*The Piano House
96 Sea Avenue
Rustington
Sussex
BN16 2DL*

23 September 2018

Application Ref: R/188/18/HH
81 Sea Avenue, Rustington

PROPOSED ROOF PLAN 1:200

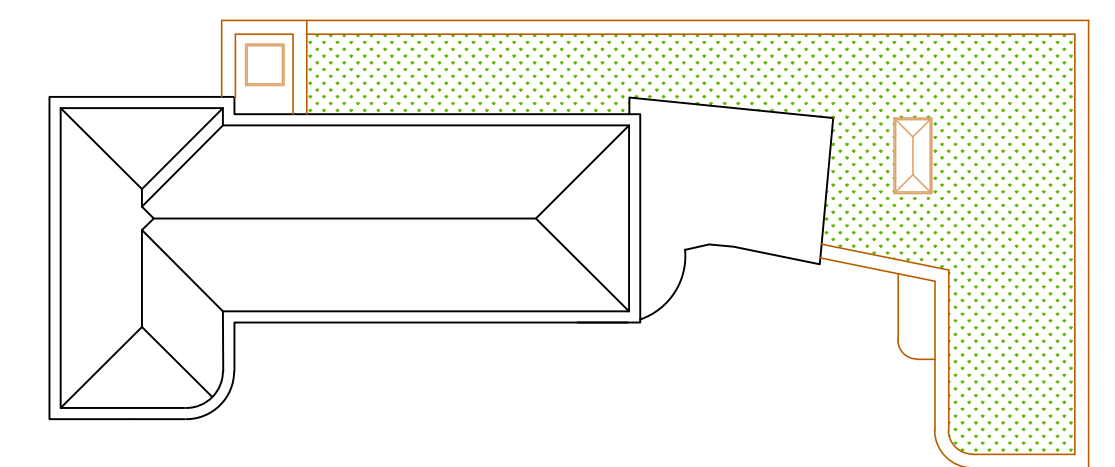
I am concerned that the single storey flat roofed extension may be used as additional balcony, verandah or sitting out area, which would adversely affect the amenities and privacy of my residential property. I have raised this concern with the Applicant and she has indicated that she would be happy to accept a condition to any approval which restricted use of the single storey flat roof.

Accordingly, I request that, if approval is granted, it includes a condition along the following lines:

"The roof of the extension hereby permitted shall not be converted or used as a balcony, verandah or sitting out area, and no access shall be gained except for maintenance purposes.

Reason: To protect the amenities and privacy of the occupiers of the adjoining residential properties."
